Application no: H06/1220/99

Applicant: S E King Building Contractor
192 Bridge Farm
New Road
Sutton Bridge
Spalding Lincs PE12 9QE
Description: Erection of chalet bungalow
and garage

Location: Plot adj. Chapel House
Main Street
Gedney Dyke
Spalding Lincs

ACKNOWLEDGEMENT OF AMENDMENT

Approved
12/03/00

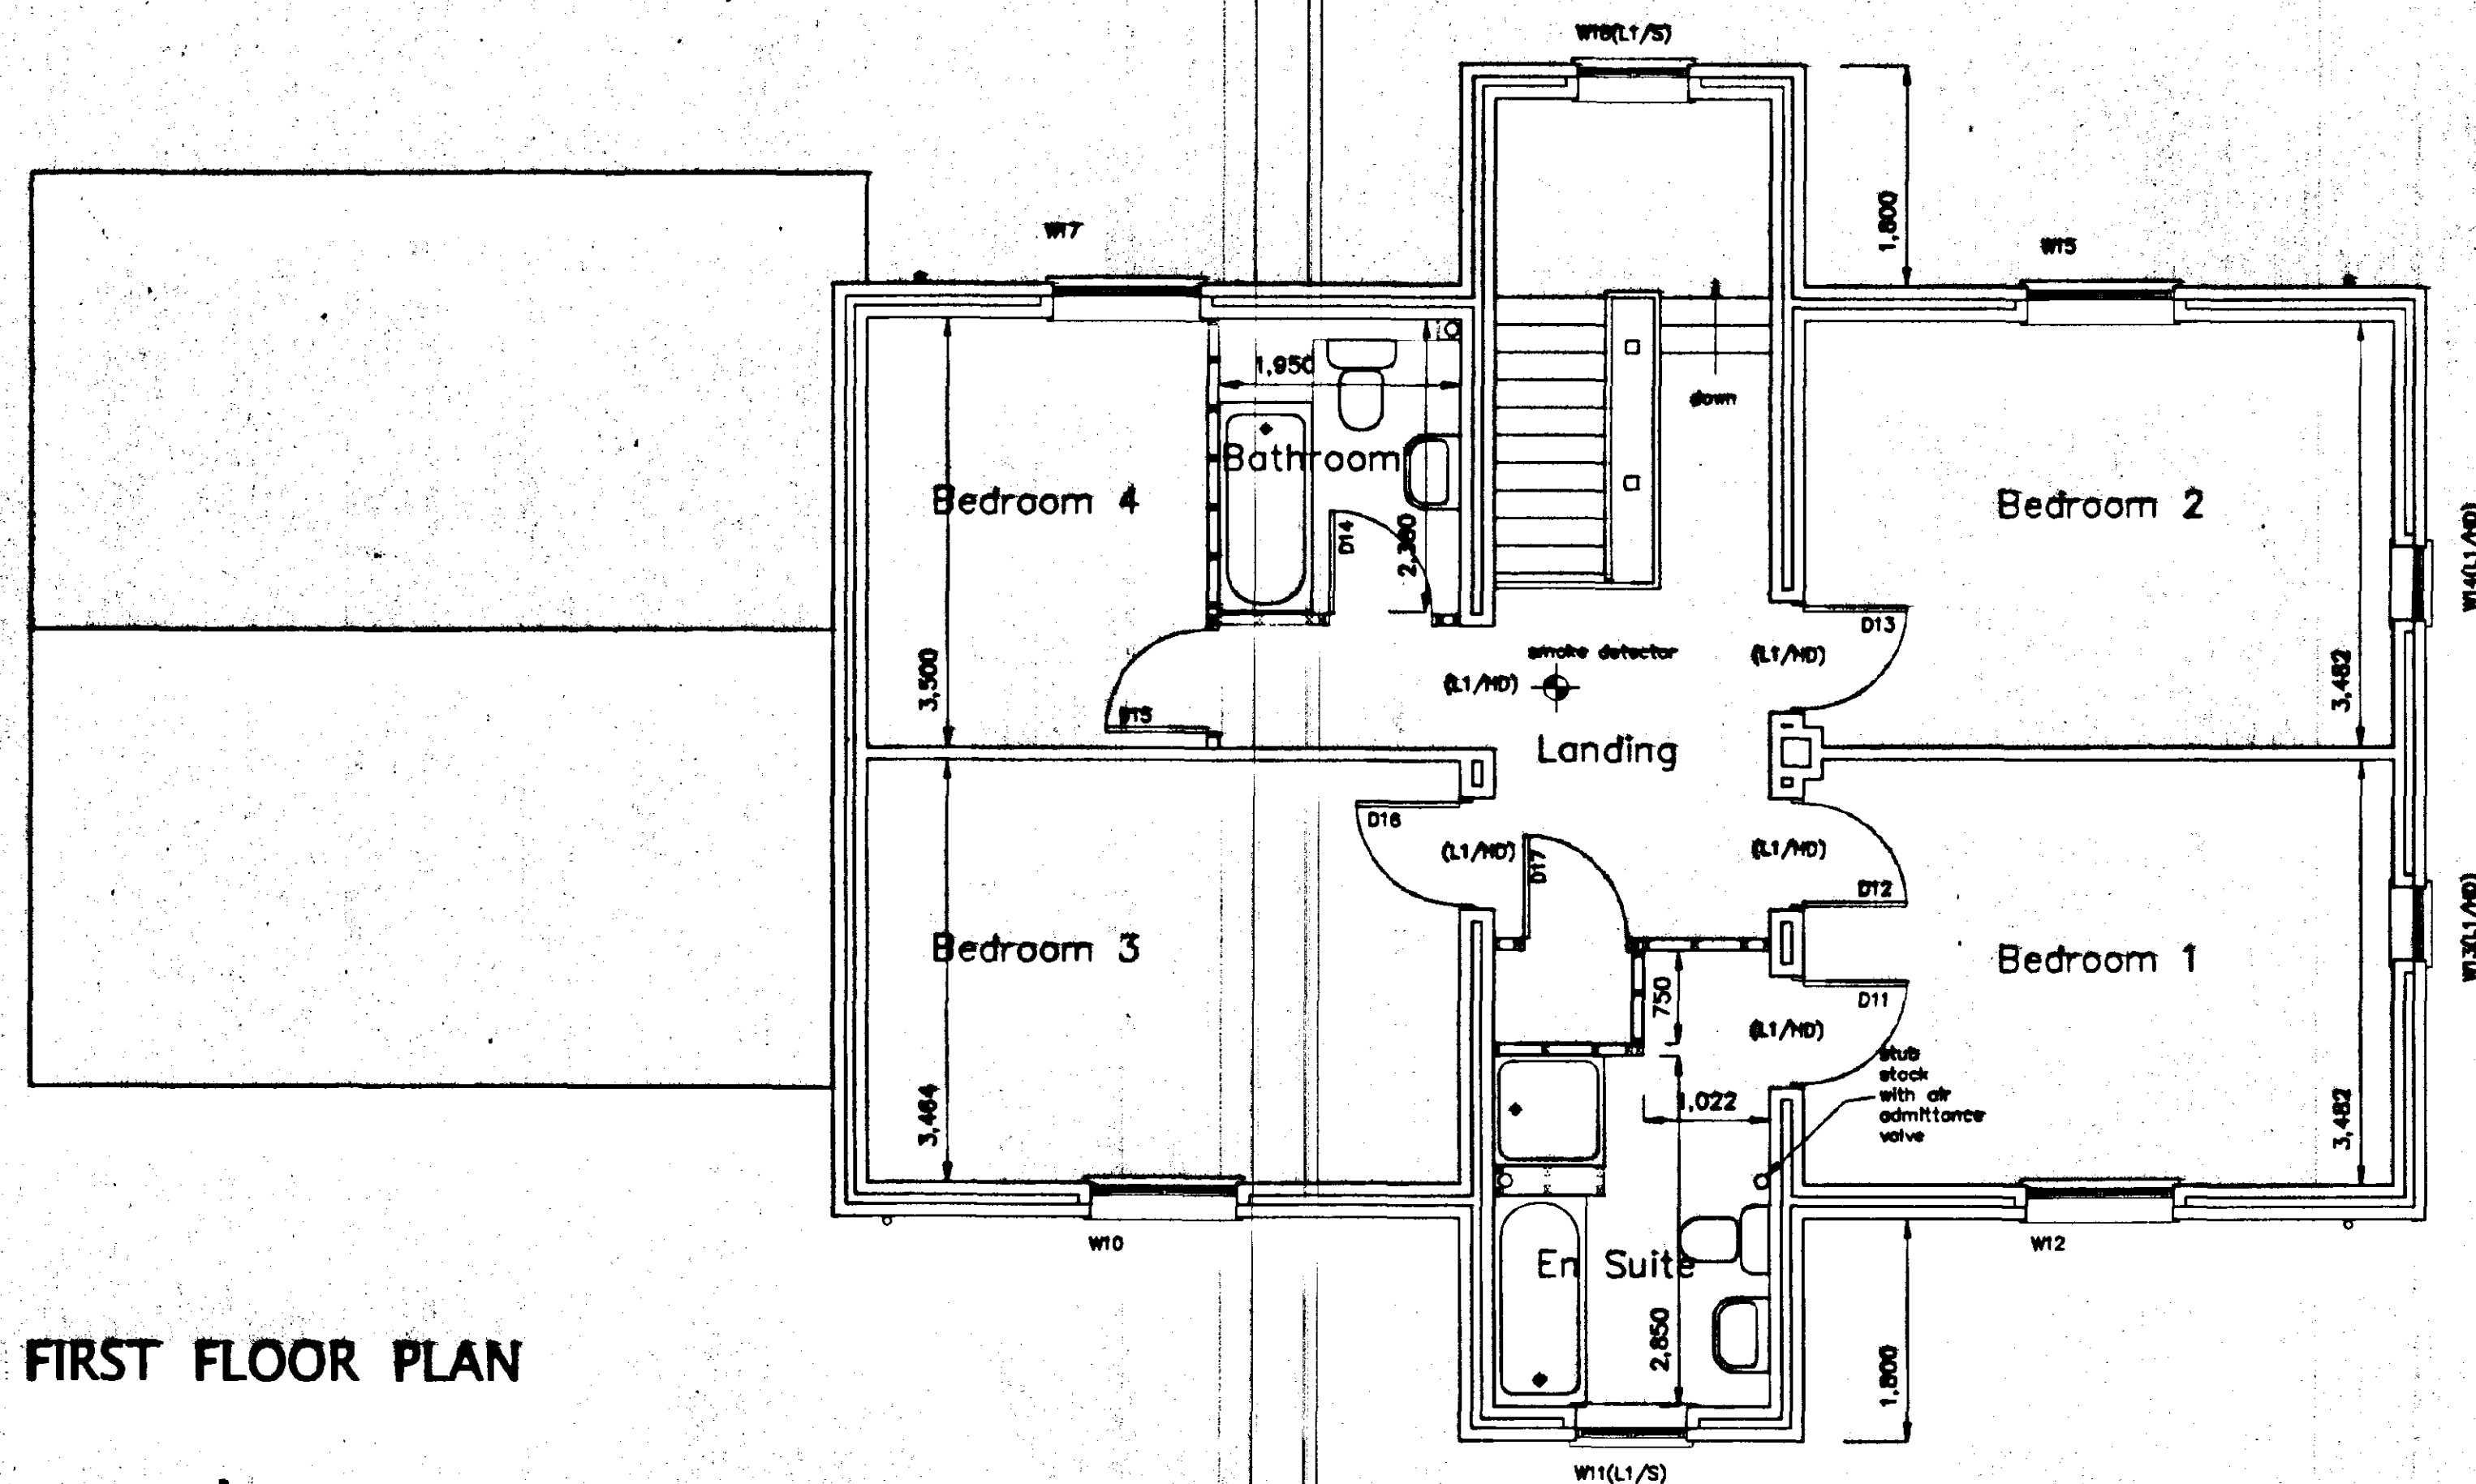
**SPRING OF DWELLING WITH
GARAGE NOW ATTACHED TO
EDGE OF TREE CANOPY SPREAD
ACCESS CENTRALISED
CENTRE TREES TO BE REMOVED.**

Amendment: Dwelling re-sited, garage attached, access re-positioned and
alternative tree to be removed.
